Arun District Council
Arun Civic Centre
Maltravers Road
Littlehampton
West Sussex BN17 5LF
Planning General Enquiries
Tel: (01903) 737756 Fax: (01903) 730442
Dx: 57406 Littlehampton
Minicom: 01903 732765
e-mail: planning@arun.gov.uk
website: www.arun.gov.uk/planning

Application for approval of matters reserved by condition imposed under LU/13/15/PL relating to conditions 5-details of obscure screening to balcony, 6-schedule of materials & finishes, 9-foul & surface water sewerage disposal, 10-surface water drainage, 11-SUDs system & 15-Construction Management Plan.

The Old Dairy Church Street, Littlehampton,

Arun District Council have decided to **REFUSE details reserved by condition for the following reasons:**

DRAINAGE LAYOUT
SHEET 1 OF 2

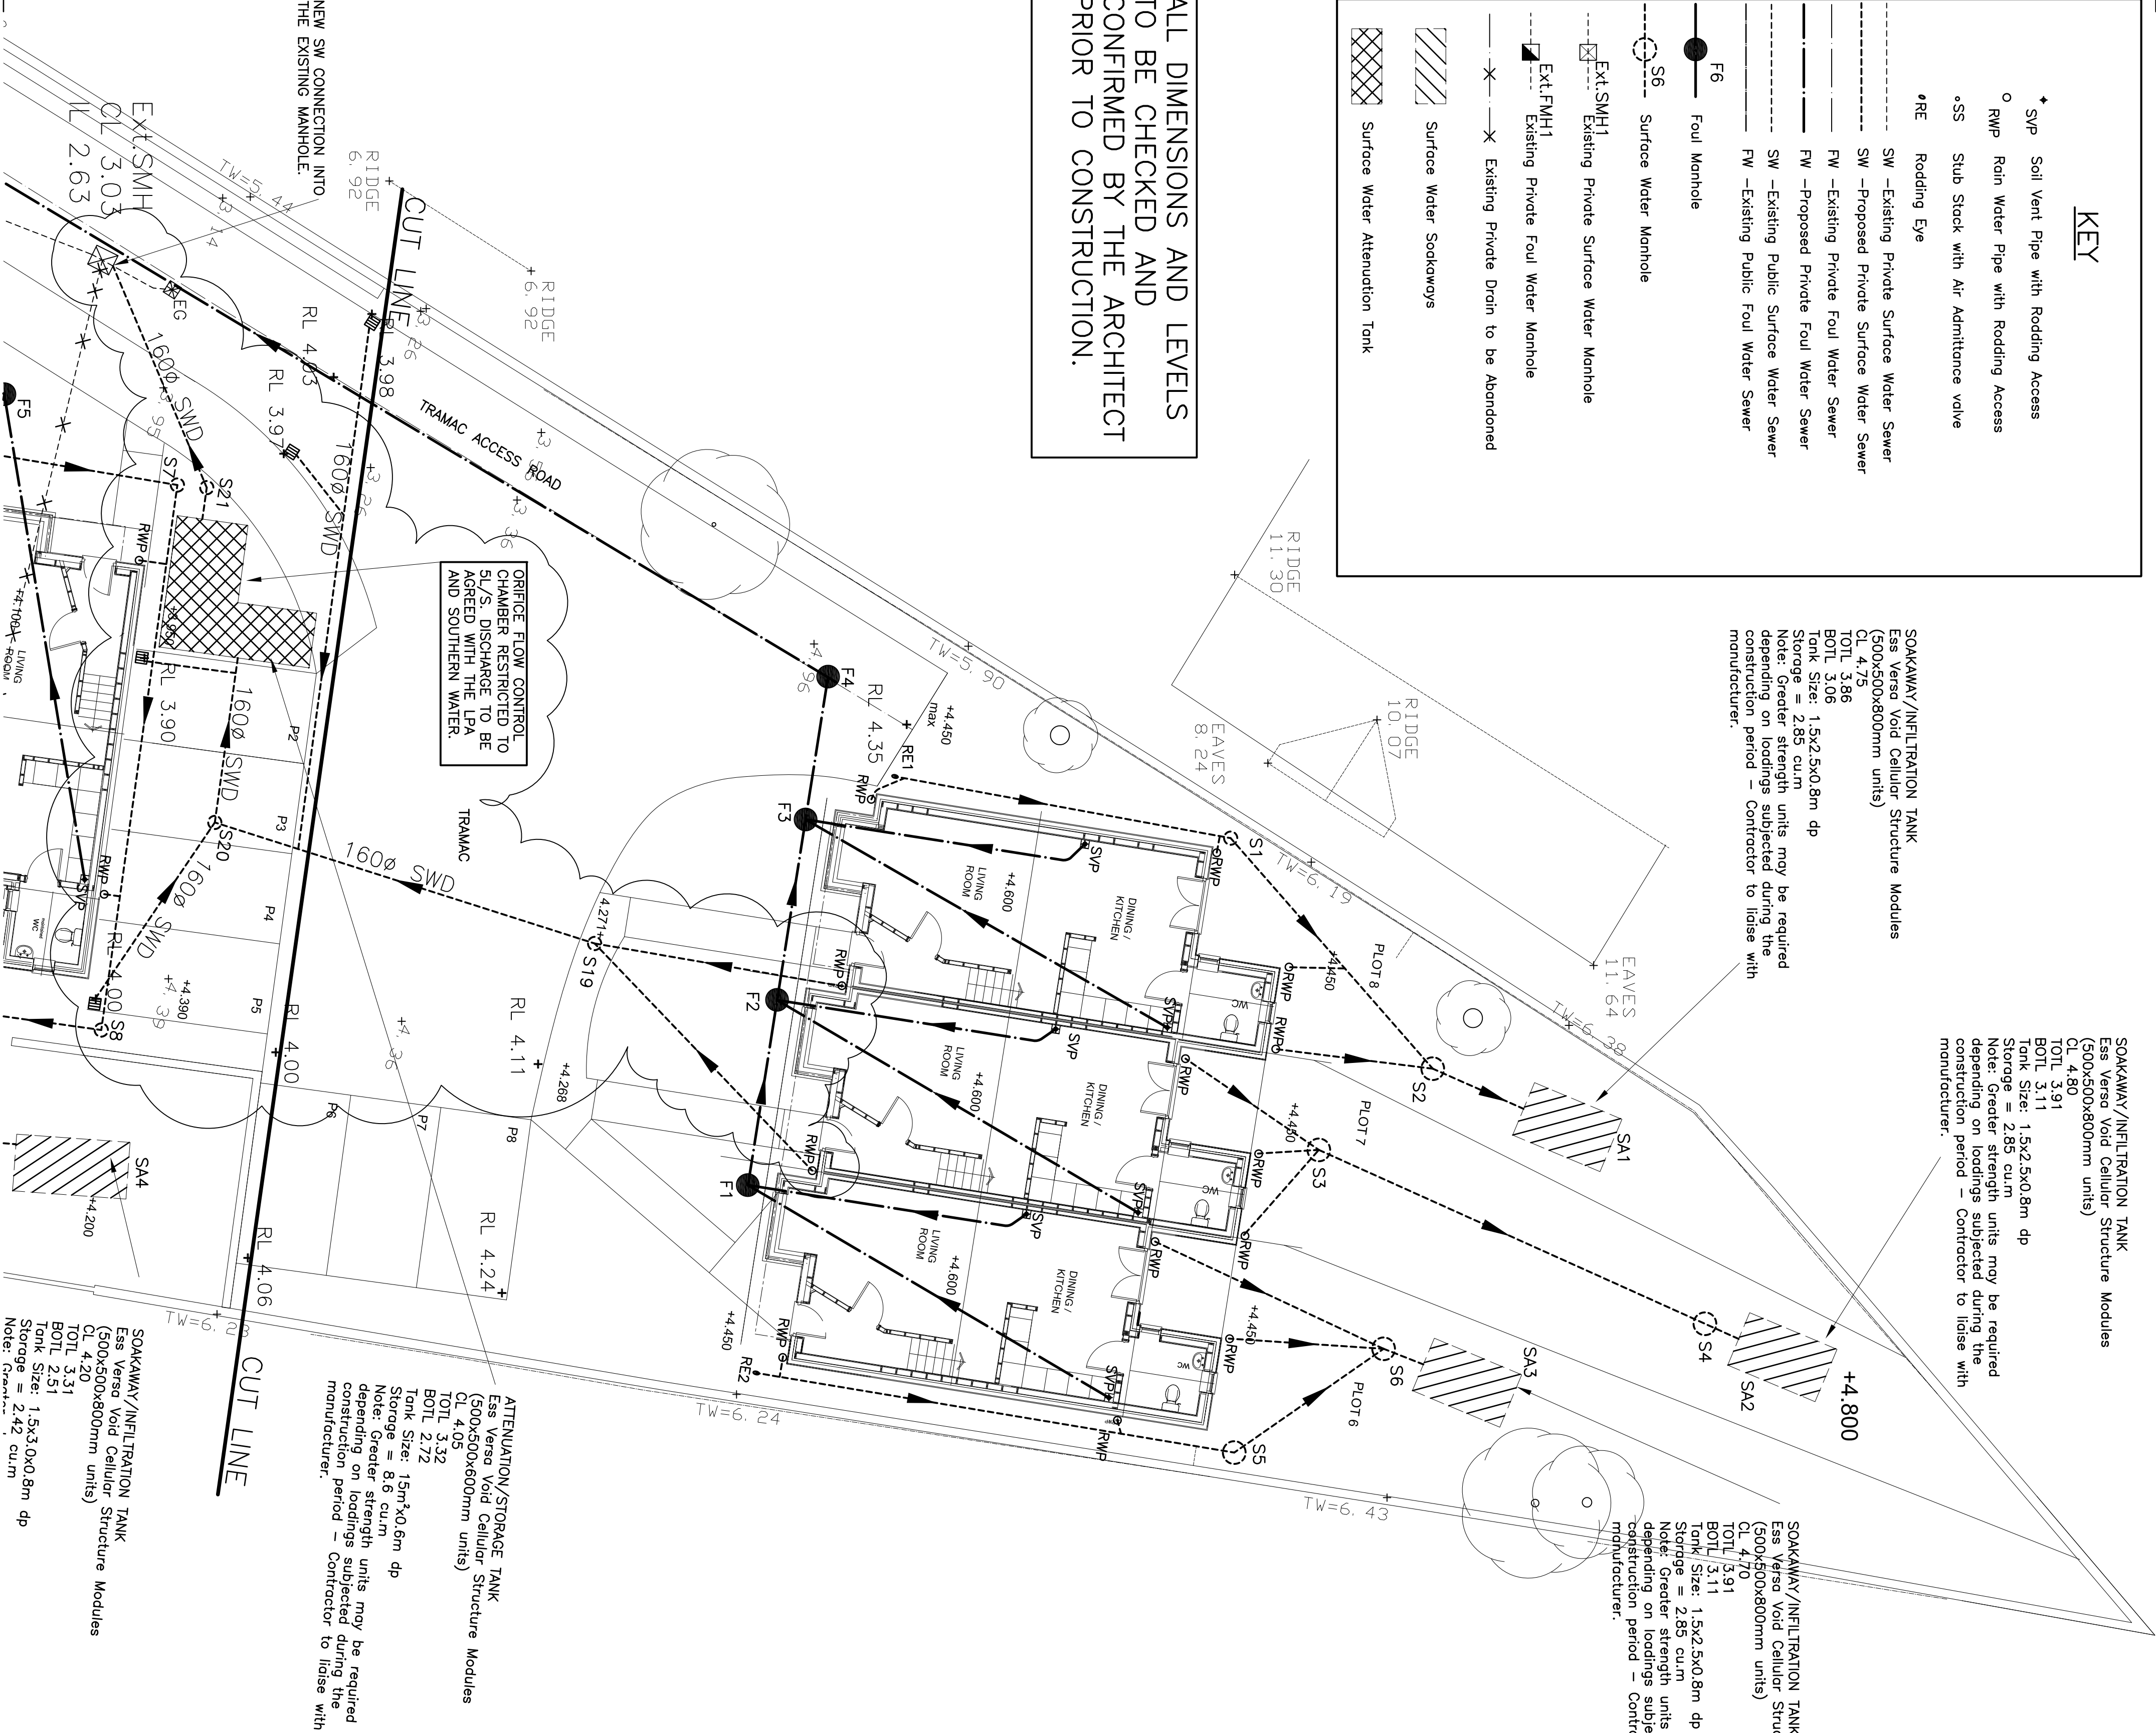
Southern Water cannot recommend discharge of condition 9,10,11. Submitted drainage layout shows part of the site discharges surface water to Soakaway and part to public sewer.

Surface water flows from the entire development could be discharged to soakaway, if the (parking) layout is re-arranged to facilitate additional soakaways. The Councils Building Control Officers or engineers should be asked to comment on the adequacy of soakaways to serve the development.
docdec1

Please note that surface water disposal should comply with part H3 of Building Regulations.

It is the responsibility of the developer to make suitable provision for the disposal of surface water. Part H3 of the Building Regulations prioritises the means of surface water disposal in the order:

- a Adequate soakaway or infiltration system
- b Water course
- c Where neither of the above is practicable, sewer
